Subject: Re: BR/64/25/PL

I'm contacting in regard to the application at 3 and 4 Queens Square (BN/64/25/PL). We are currently in the process of reviewing the application, and as an objection has been received from Bognor Regis Town Council, are evaluating whether we are in a position to be able to recommend approval, and take this to be determined at the Planning Committee.

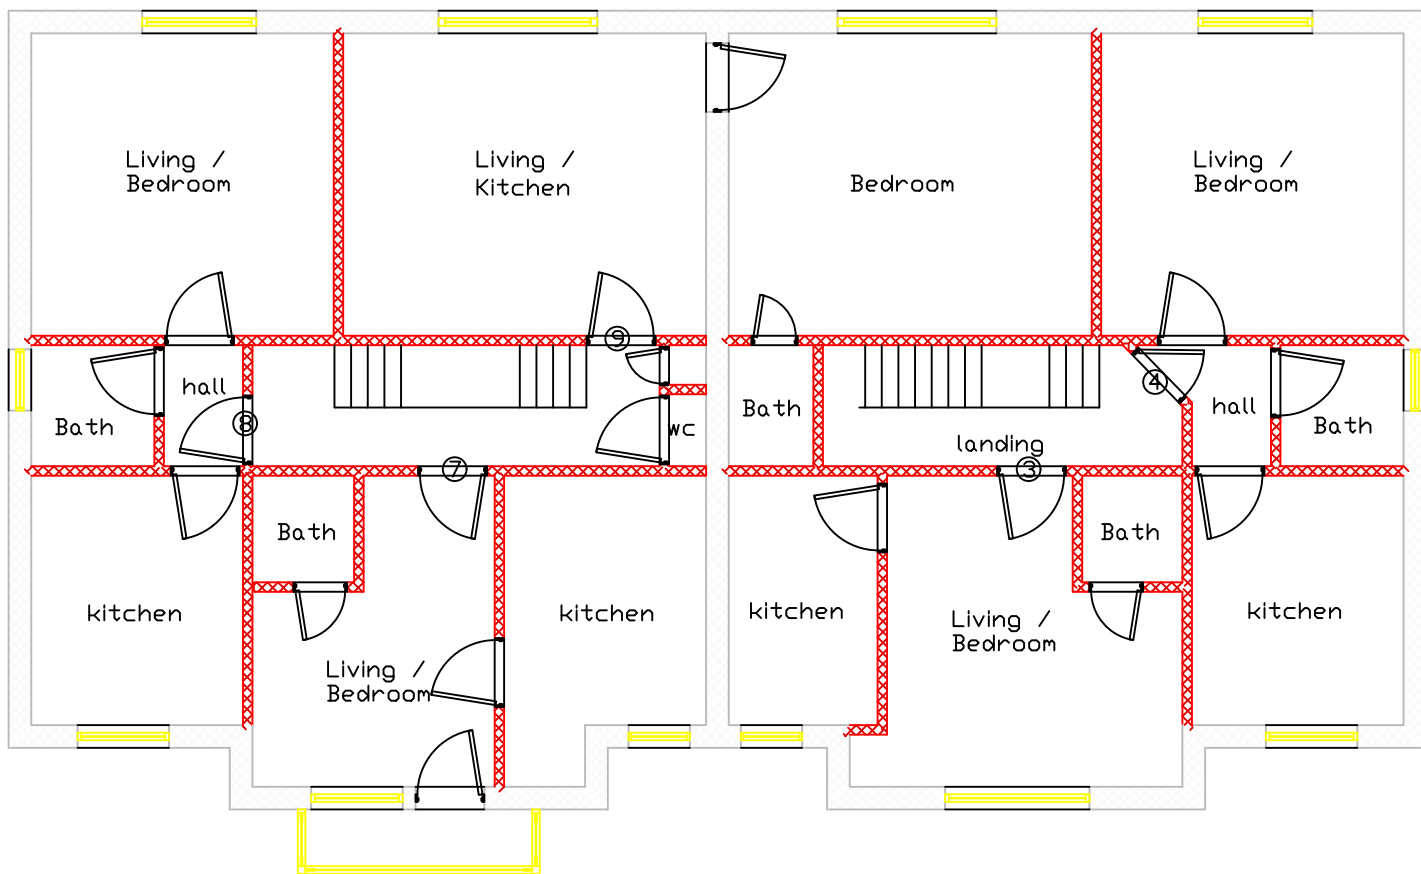
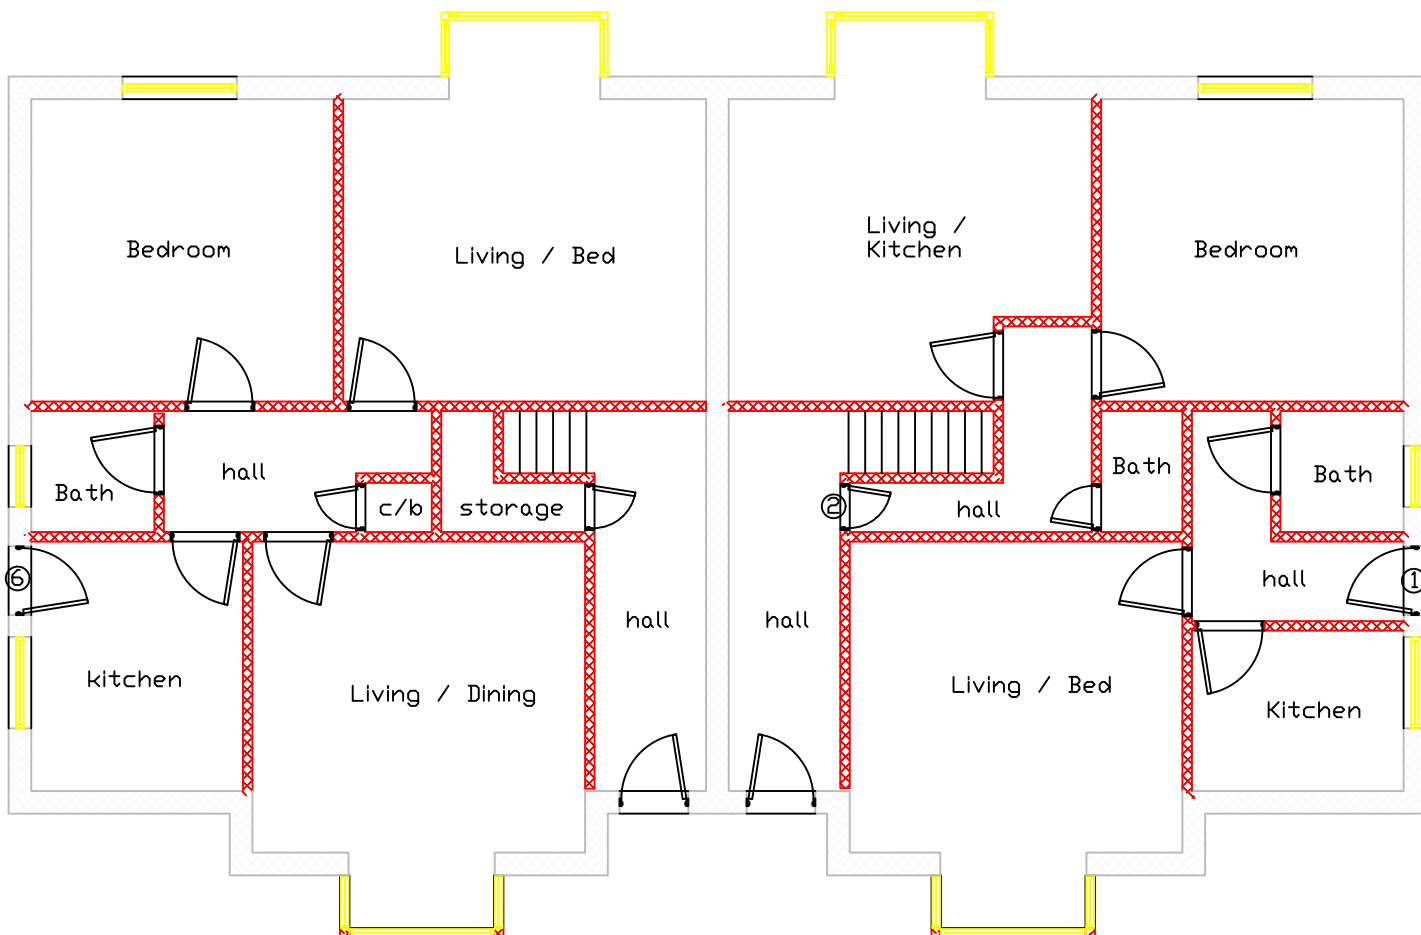
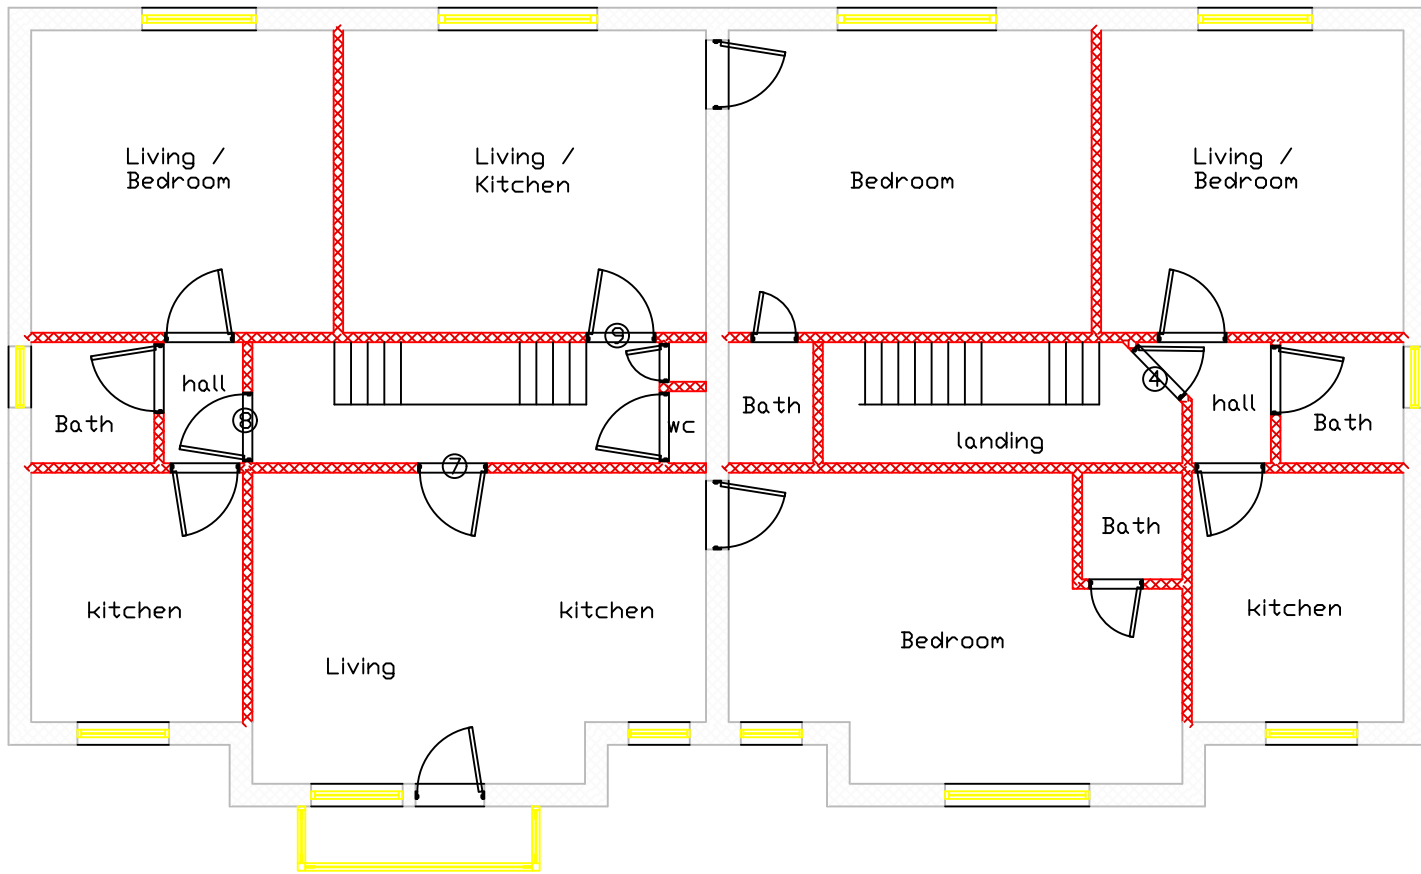
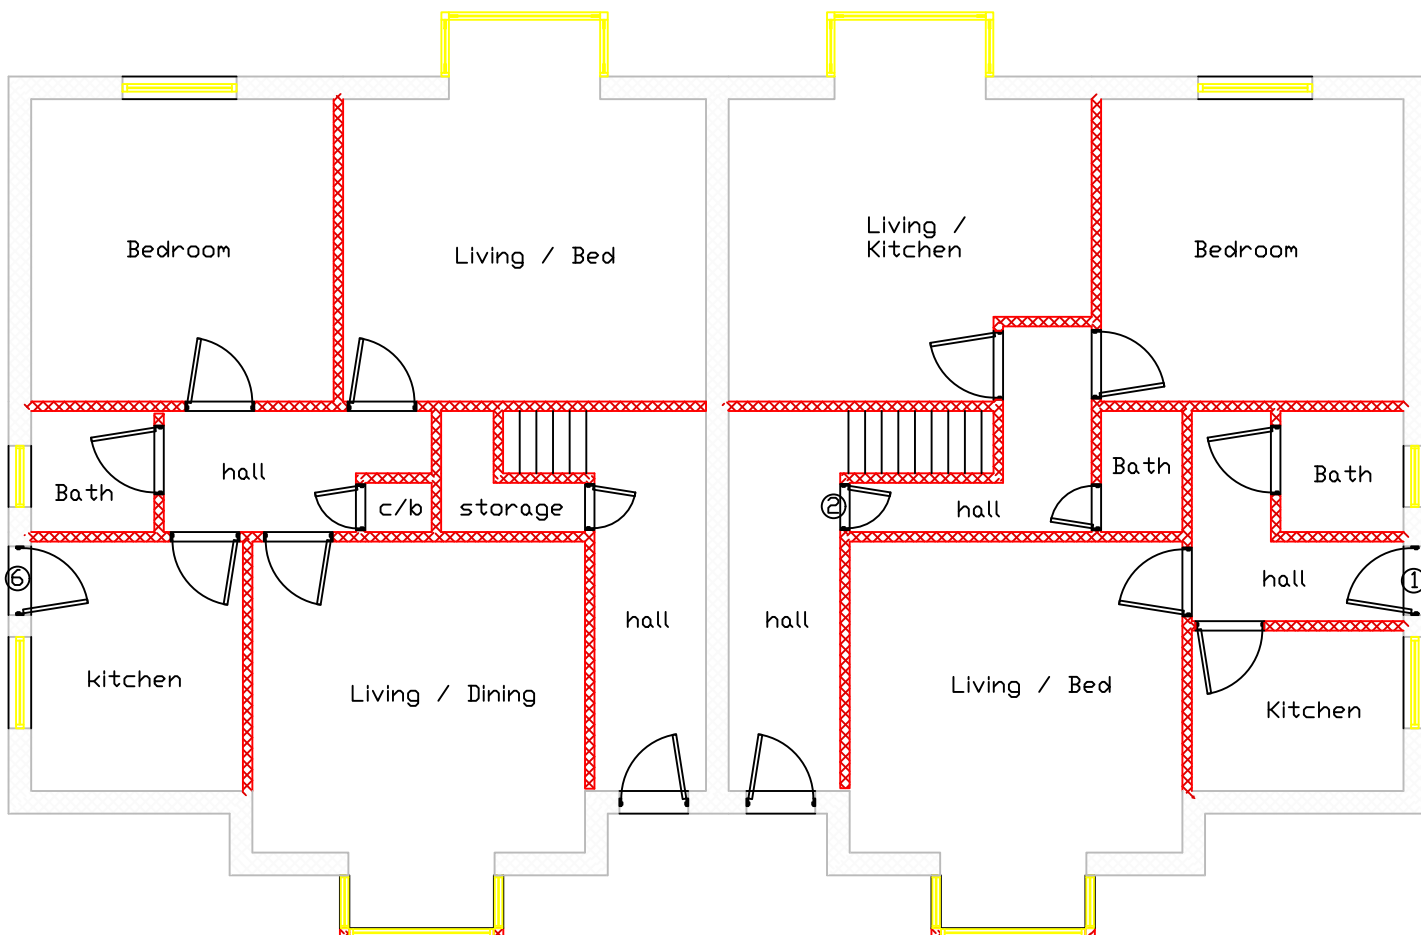
Whilst we are not opposed to the principle of the change, we have identified there a 5 units which do fall short of the minimum required internal area for 1 bed flats under the NDSS ([Technical housing standards – nationally described space standard - GOV.UK](https://www.gov.uk/technical-housing-standards)). We use the NDSS to assess proposals against Policy D DM2 of the Arun Local Plan, and ensure that the internal space being provided to occupiers is sufficient to provide a good quality living environment, and meets their needs. In this case, the following flats fall short of the minimum 37sqm set by the NDSS:

1. Flat 1 = 34sqm
2. Flat 3 = 23sqm
3. Flat 4 = 30sqm
4. Flat 7 = 23sqm
5. Flat 8 = 30sqm

that we will be able to support this scheme as it is at present given there is such a shortfall between the required 37sqm and proposed 23sqm.

As a result, we were wondering if there was any possibility that flats 3 and 7 could be combined to create a single flat? This would create a floor area of approximately 46sqm, which would sufficiently exceed the minimum 37sqm, and comply with policy D DM2.

In order to ensure officer support, we reluctantly agree to your request and therefore please find attached Drawing 5A which merges units 3 and 7.
